RE: Marist Catholic College North Shore (SSD-10473). Response to Submissions and peer review. NSW Government, Department Planning, Industry and Environment (DPIE)

This Heritage Impact Statement (HIS-APPENDIX A, B and C) has been prepared in accordance with the DPE Response to Submissions (RtS) for proposed alterations and additions to the Marist Catholic College North Shore (SSD-10473), dated 20th December 2021.

APPENDIX A: SUMMARY TABLE Marist Catholic College North Shore (SSD-10473). Response to Submissions.

1 GROUND - PARISH CENTRE/CANTEEN

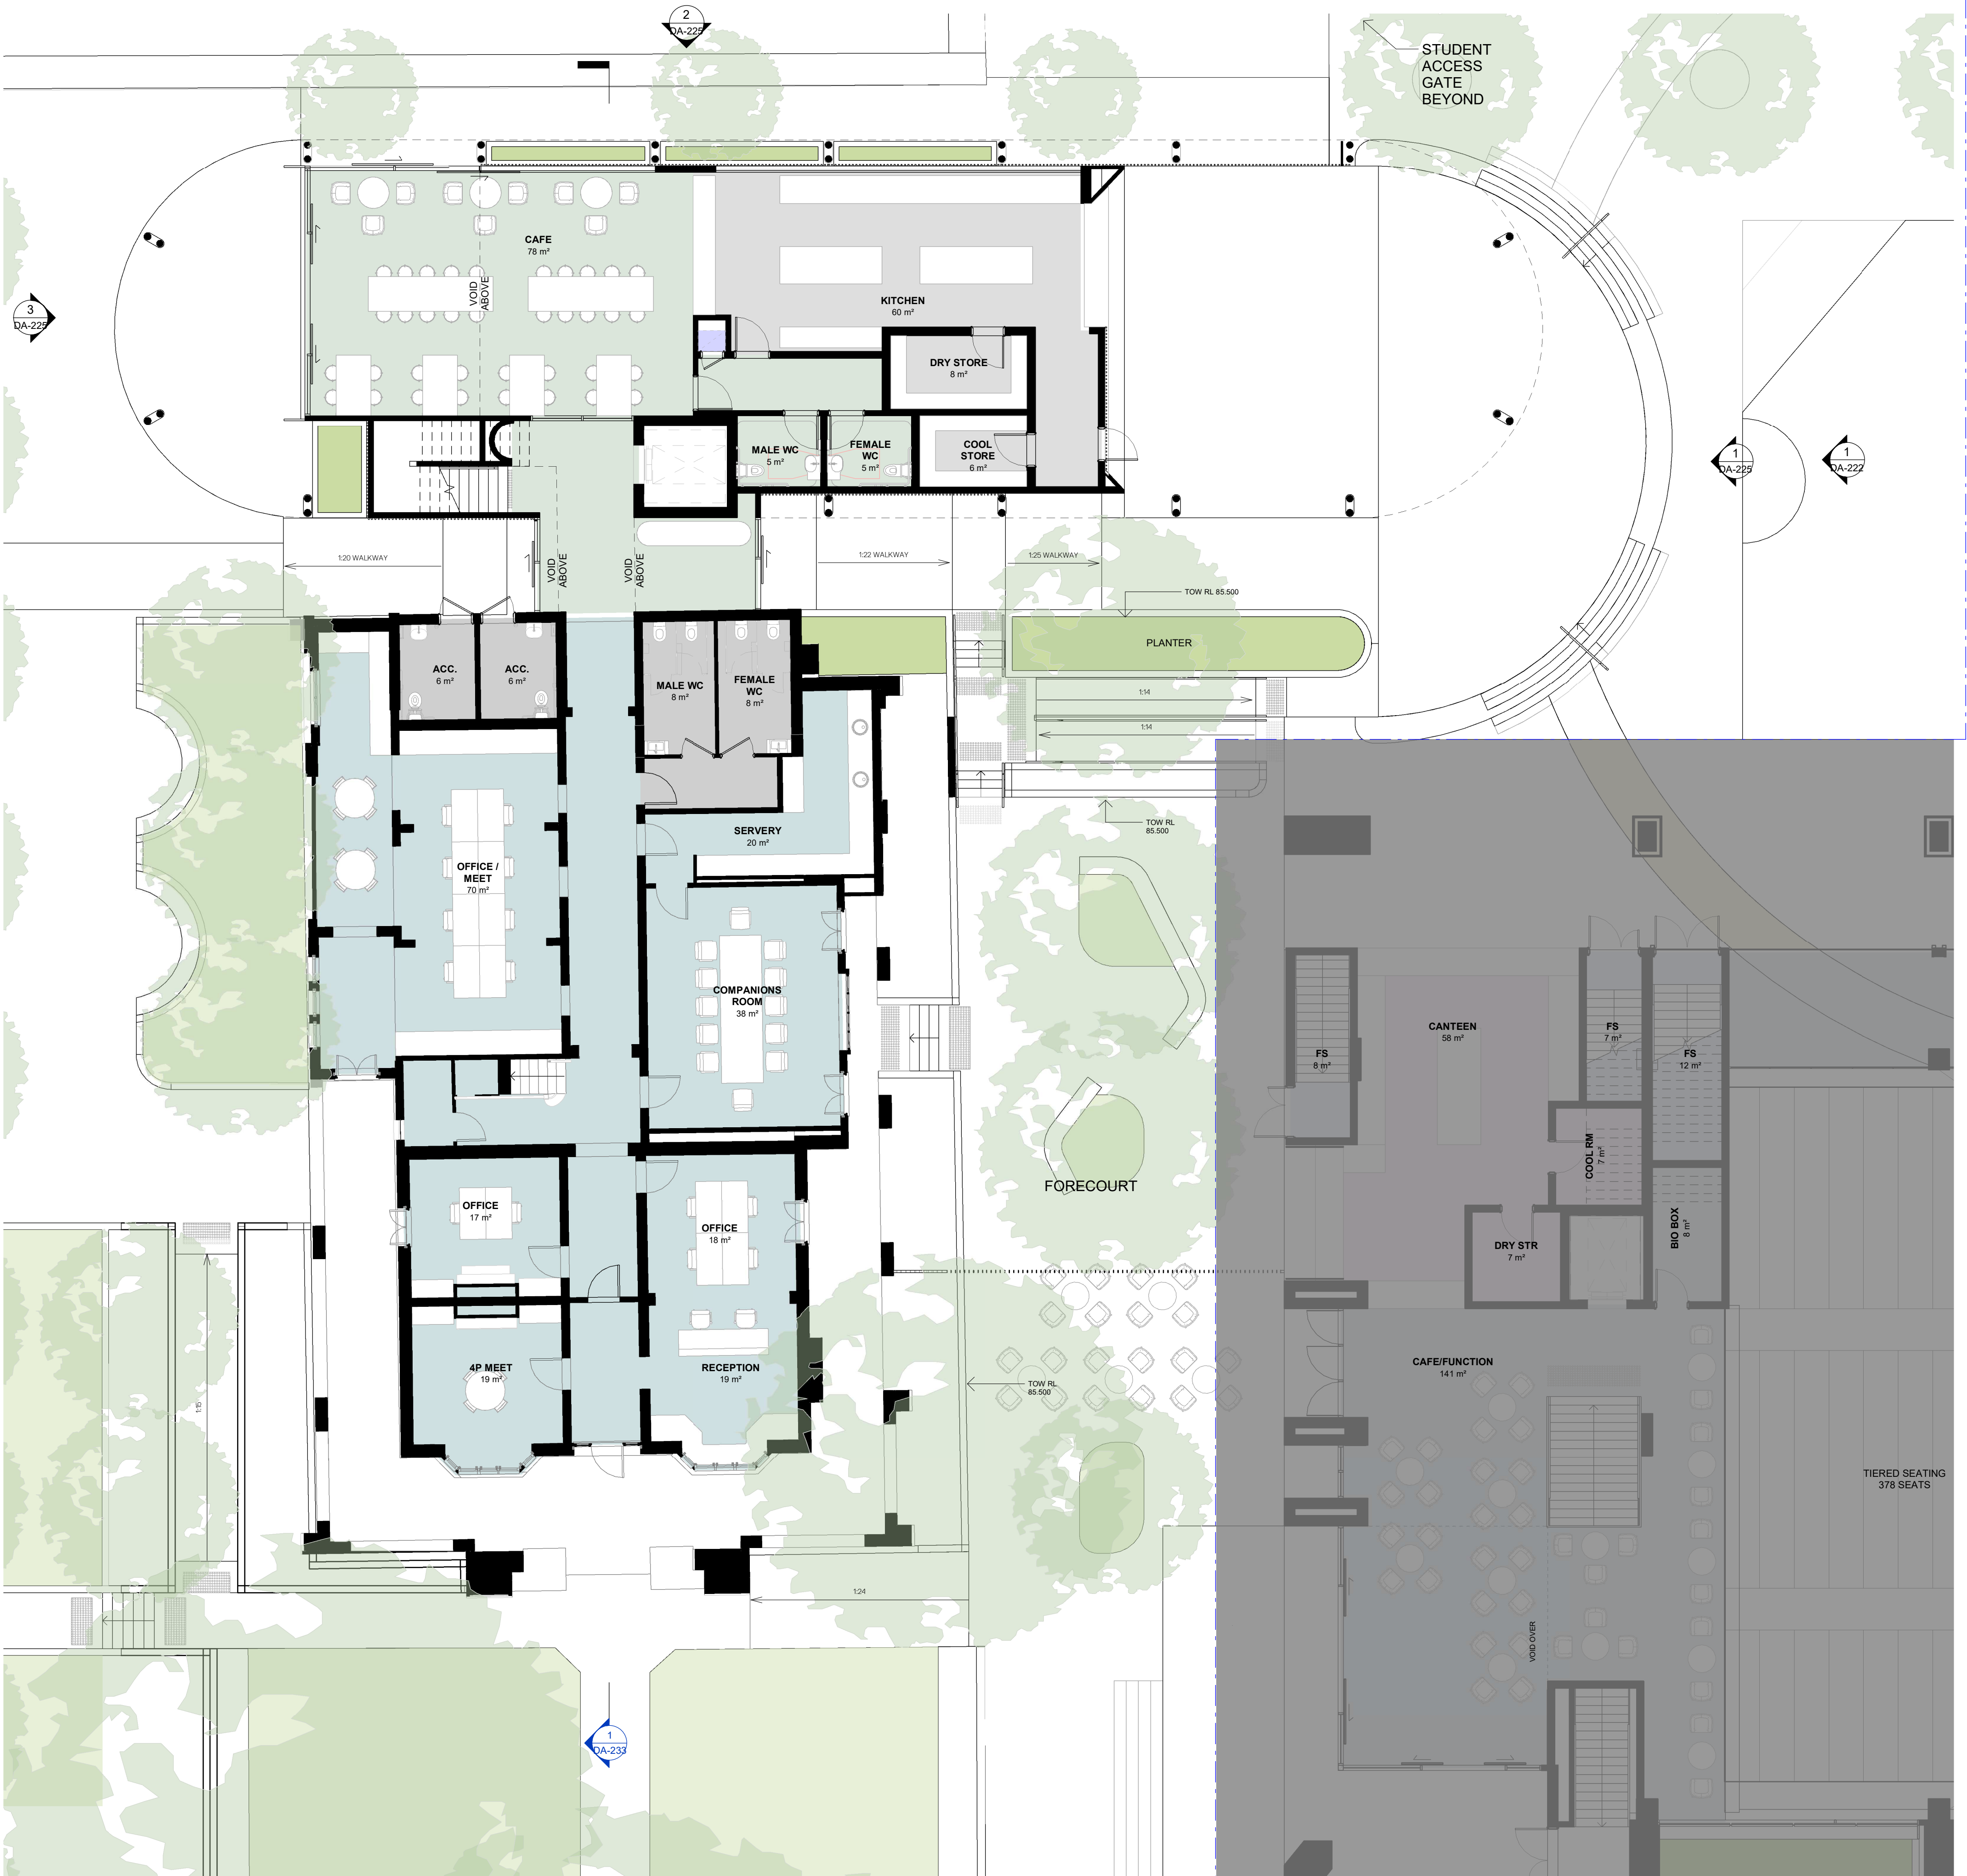
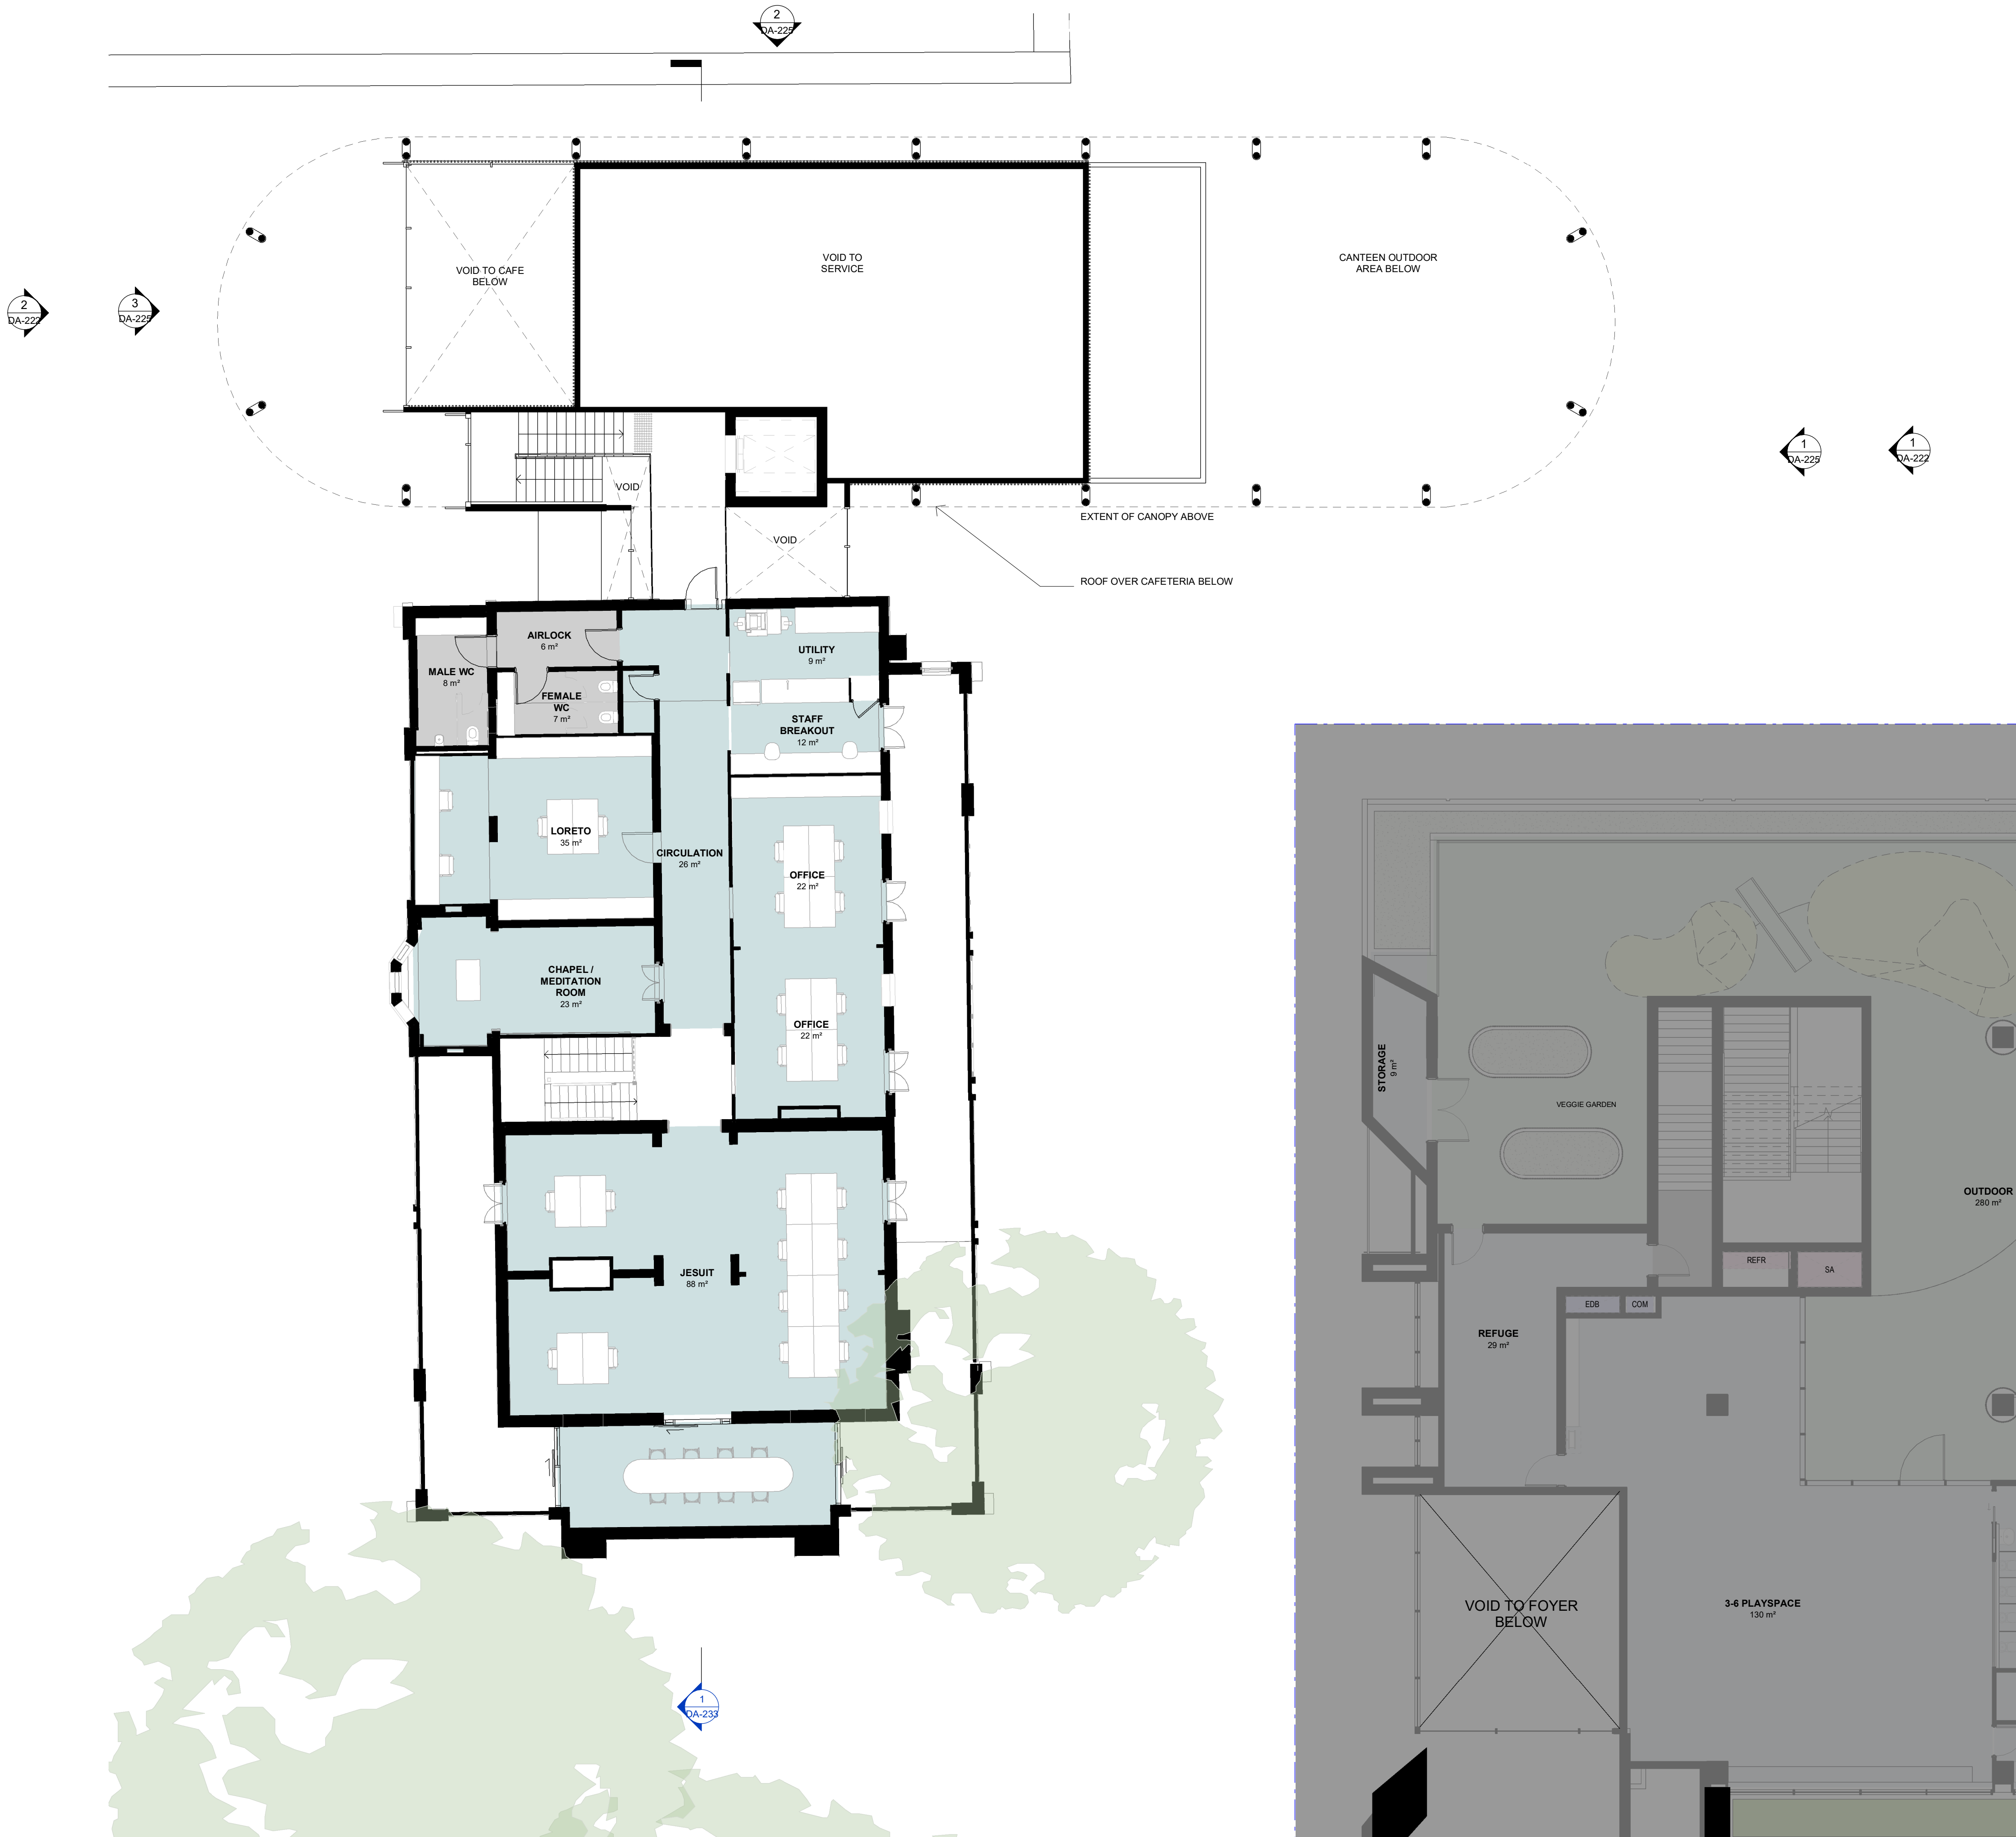
8.0	Provide drawing scale on the plans	Plans have been updated to show scale. Refer to architectural drawings.
9.0	Identify the setting and curtilage of the Church Group. Provide an analysis of the impact on the setting and the Group by the proposed landscaping. Provide more detail on the proposed Canteen building and any impact on the Presbytery.	An analysis is provided on the impacts of the Church Group by the proposed landscaping in Appendix A. Architectural drawings have been updated to provided more detail on the Canteen building and impact on Presbytery. Refer to architectural drawings.

- The proposed works will remove the intrusive demountable buildings, decking and fencing to the rear western elevation of the building and replace them with a well considered, articulated and high quality design that forms part of the materiality and architectural style of the proposed suite of buildings for the site. The proposed canteen structure connects lightly to the presbytery, via a glazed walkway on the less significant, western elevation and is not visible from the public domain.
- The proposed Canteen building sits below the eave height of the Presbytery, which reduces the Canteen's bulk form and scale in relation to the presbytery.

- The proposed Canteen is visible from view corridors within the site. It is a well mannered and considered design and will sit comfortably and appropriately within the suite of contemporary school buildings on the site, that are also adjacent to the Presbytery and have shared view corridors.

- The proposed materials of the canteen include an anodized metal, face brick, concrete and glass. Which are common and durable materials appropriate for use in school environment. The contemporary architectural style, materials and muted tones are articulated and detailed to be recessive and to compliment the Federation style of the Presbytery building.

- The proposed additions will provide greater flexibility and usability of the Presbytery and enable accessible compliance via the proposed lift in the Canteen building.
